# fae review1.pdf Markup Summary

SF-23-003

Any of these items which were accounted for in the Early Grading FAE can be removed. If they are new or additional, leave them in.

SHEET 3 OF 4

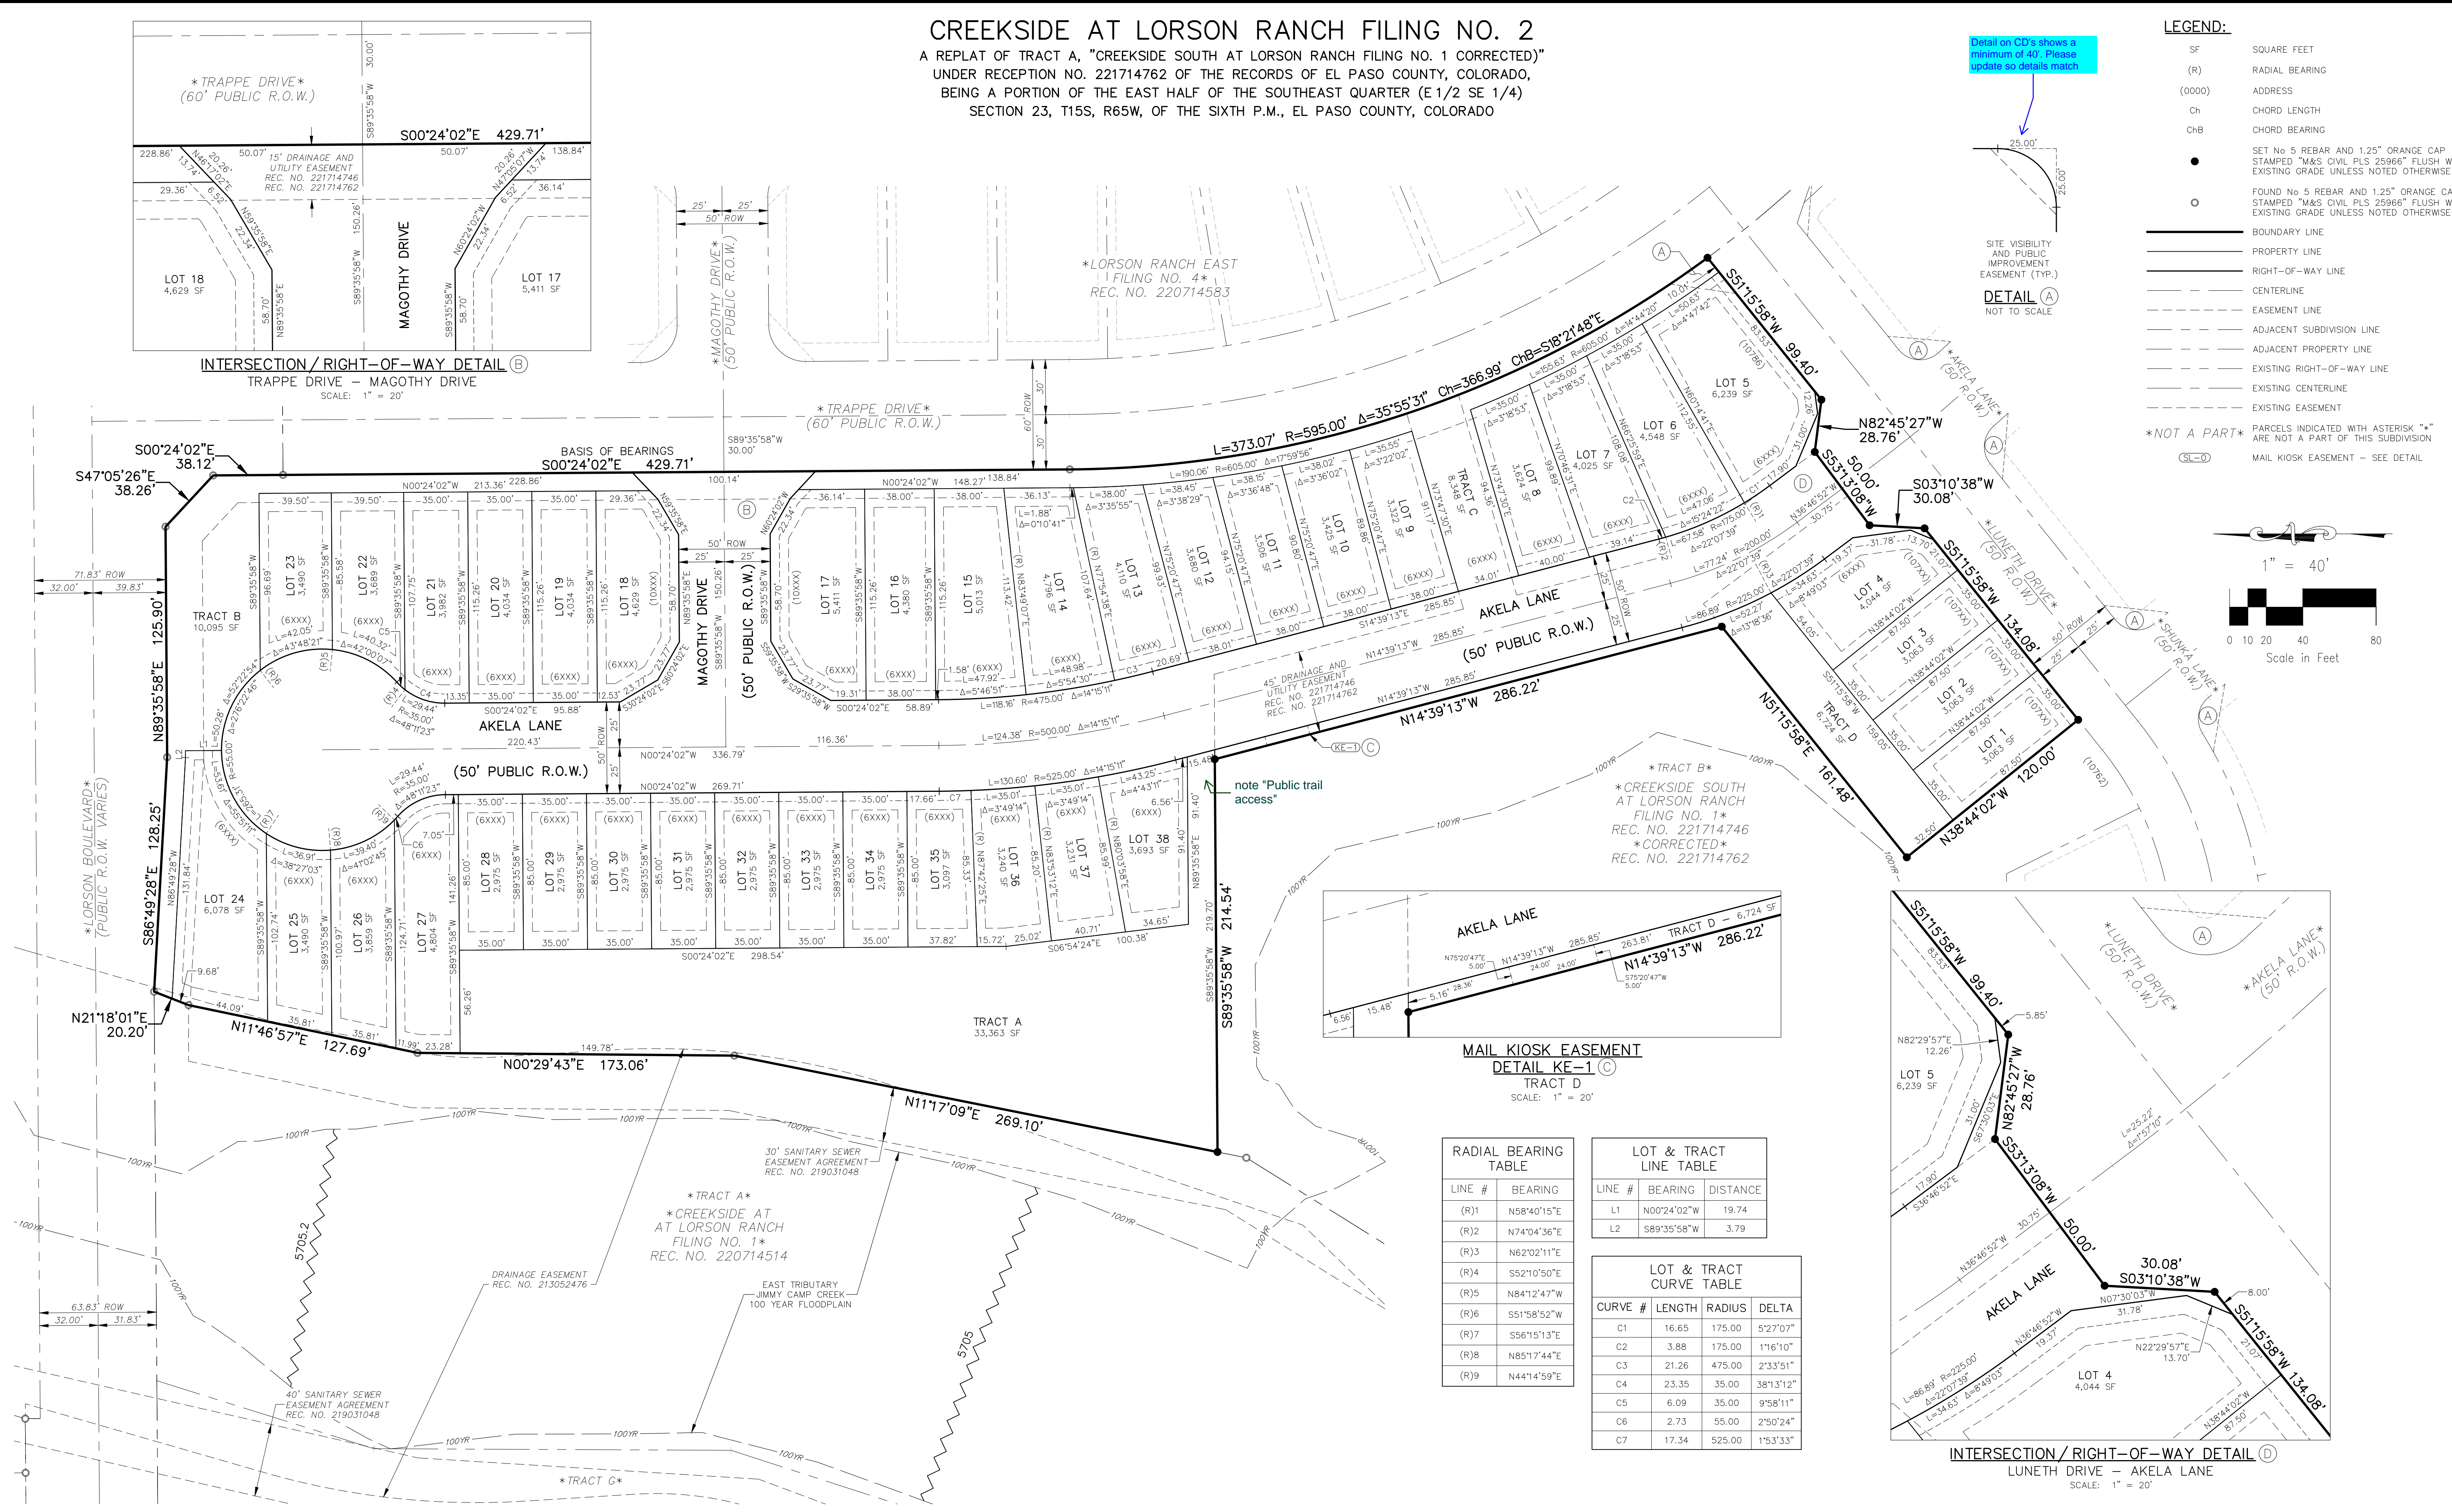
tract A trail add please

trail added
